DECISION NOTICE

Application Ref: R/197/20/OUT

Croft Works
52 Mill Lane
Rustington
BN16 3JN

Outline application with some matters reserved for the demolition of existing dilapidated storage buildings & erection of 2 No. detached 3-bedroom chalet bungalows with associated car barns, gardens, car parking & landscaping (resubmission following R/117/20/OUT).

SITE PLAN 1:250

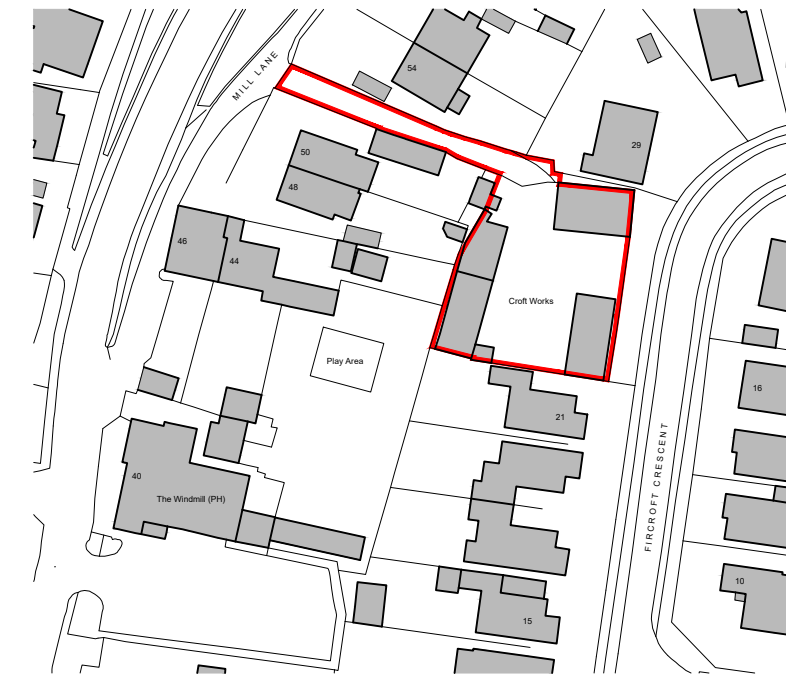
- 1 The proposal by virtue of its narrow access lane will endanger pedestrian safety and prevent access by emergency vehicles contrary to policy T SP1 of the Arun Local Plan and paragraph 110 b), c) & d) of the National Planning Policy Framework.
